## Hinckley National Rail Freight Interchange

### Interested Party Reference number: **20038309**

[Appendix 2 Response Report Sapcote Enhanced Scheme](#)

[Sapcote Technical Note \(Appendix 2C\) Details of Enhanced Scheme](#)

**SAPCOTE ENHANCED
SCHEME
VISIBILITY TO
PEDESTRIAN CROSSINGS**

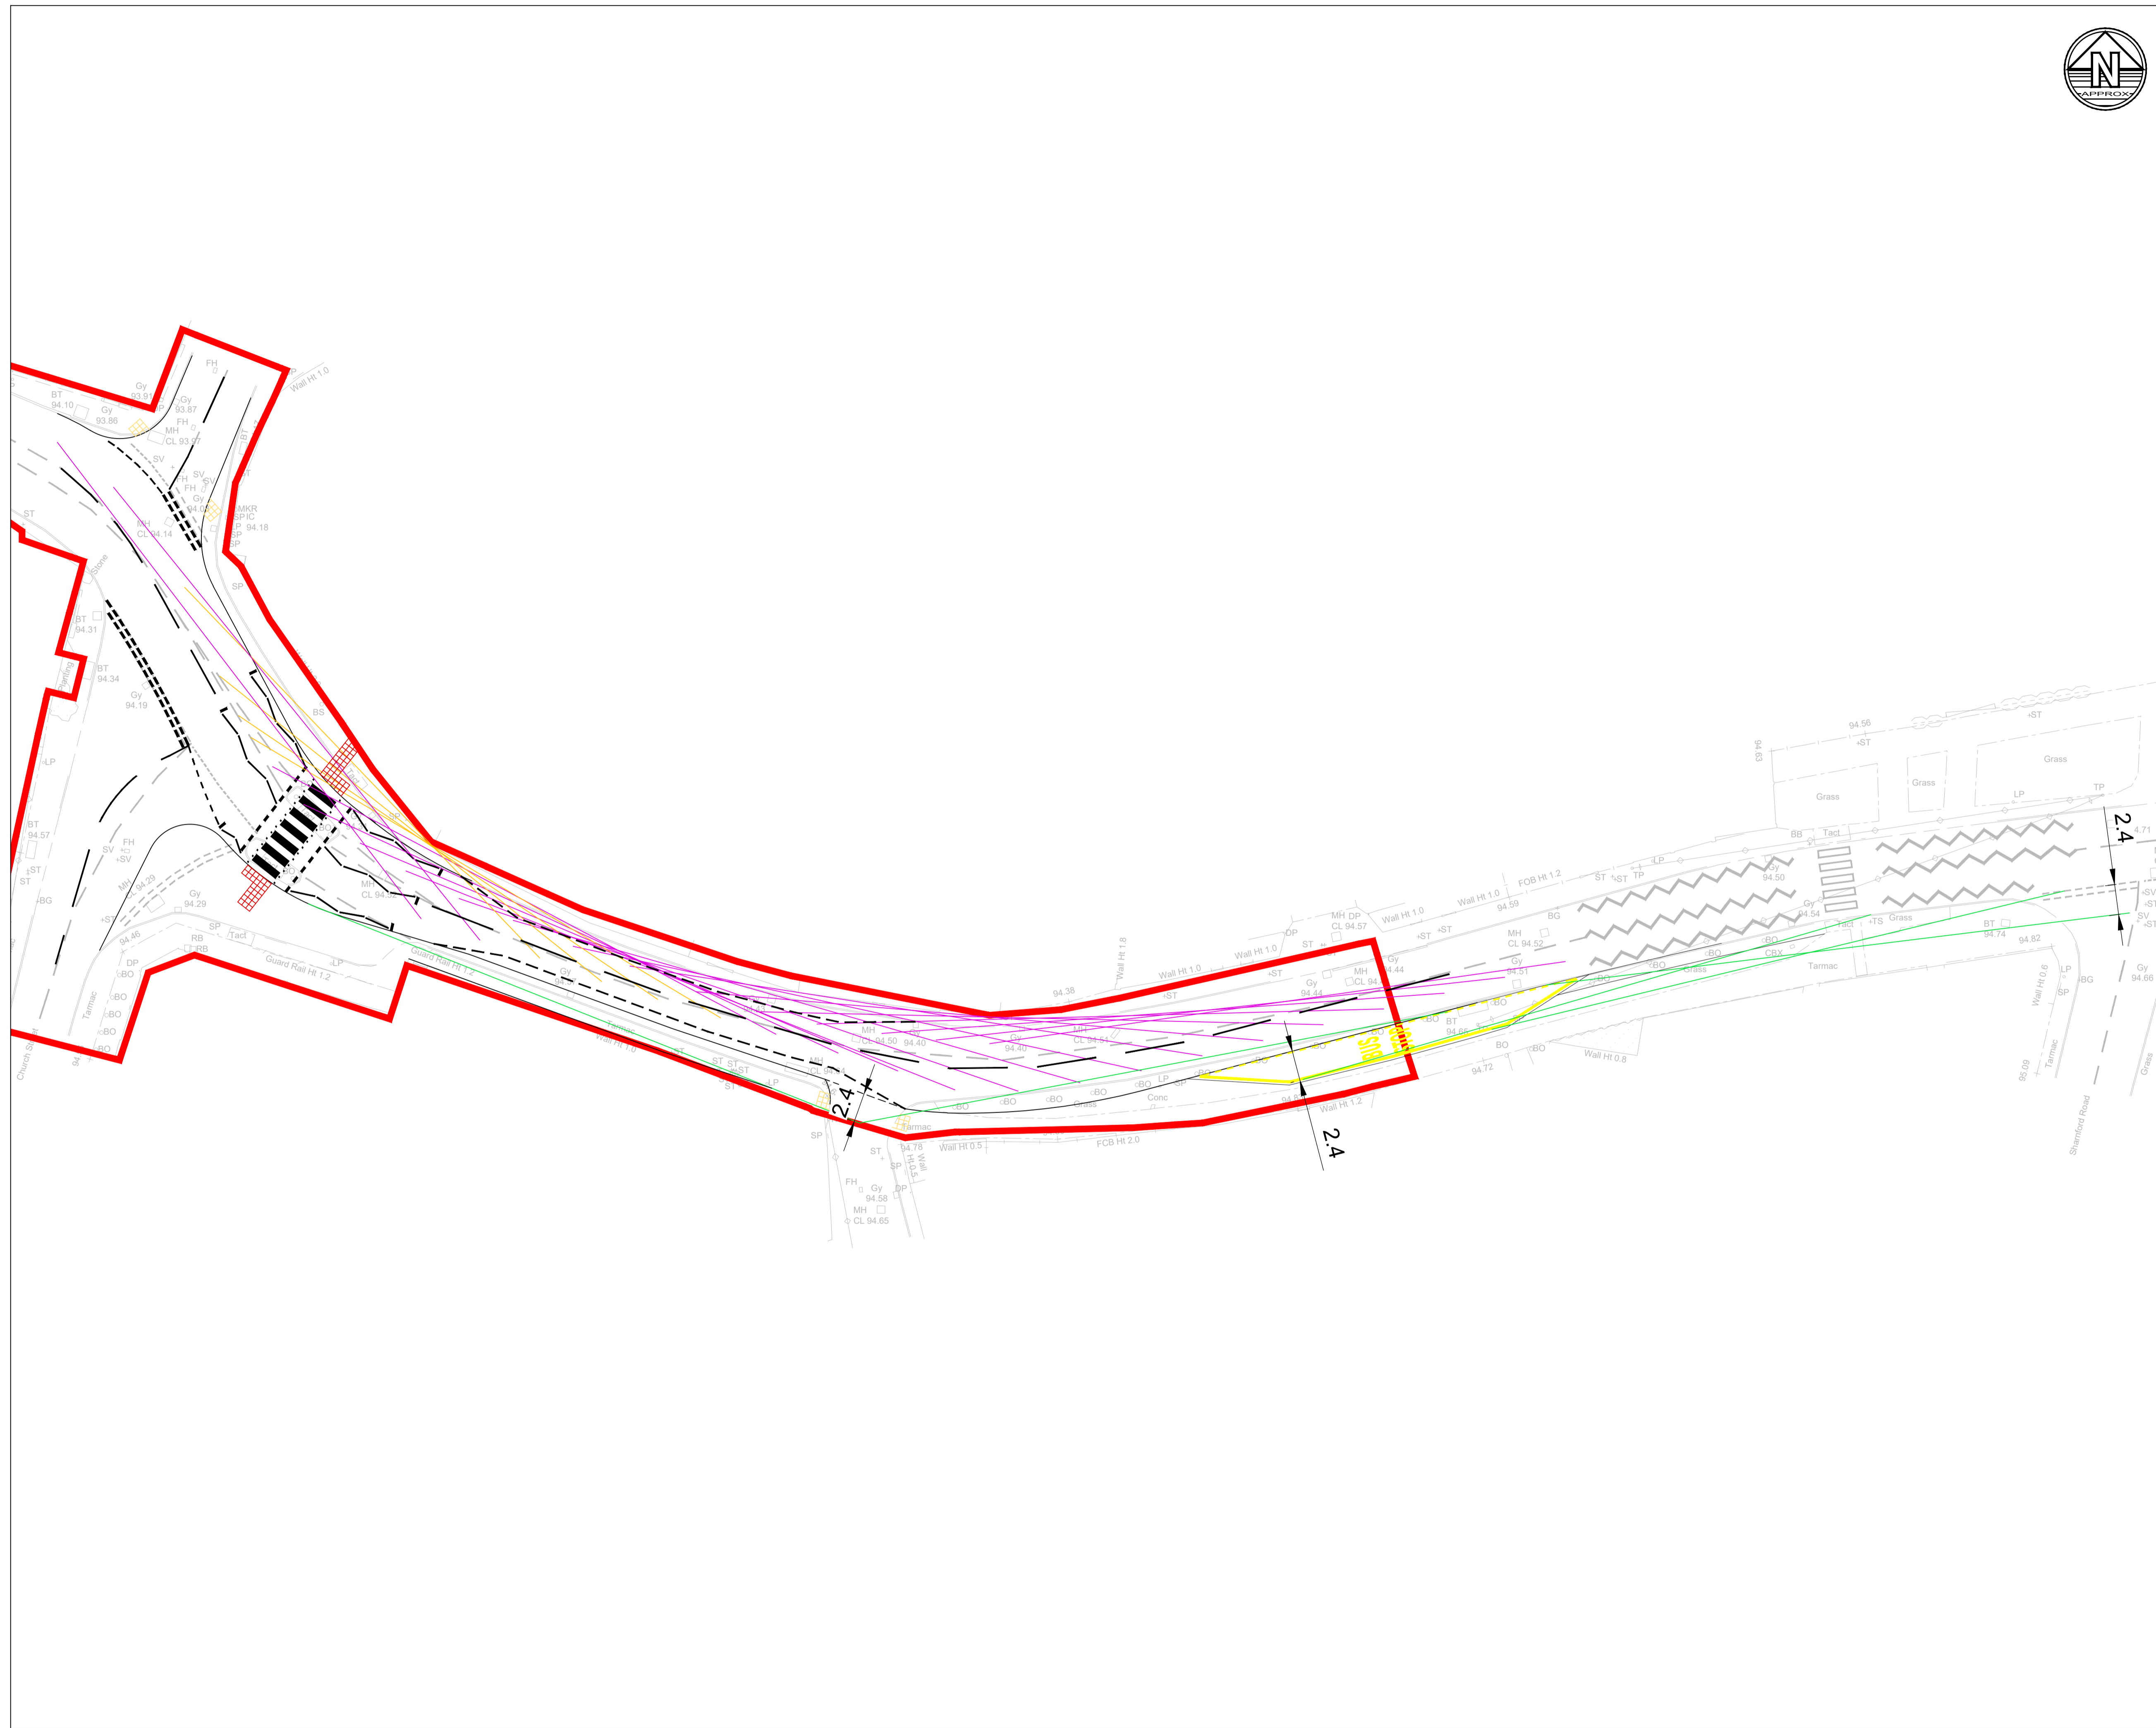
Regarding restricted visibility due to cars parked outside Sapcote Club. This also applies to observations about illegal parking and loading outside the Coop. The imposition of waiting restrictions does not address the problem as there is insufficient parking in Sapcote with the Coop carpark frequently full or blocked by lorries unloading. There needs to be sufficient parking created to free up these spaces before this can be implemented.

The proposed "vehicles in the middle of the road" seems unworkable as it depends on vehicles giving way with no one having right of way. Vehicles travelling from the proposed development will not see on coming vehicles travelling in the opposite direction until they are on, or just past, the proposed crossing. Stopping on the hatched areas other than to allow pedestrians to crossing is, I believe, a violation of traffic laws.
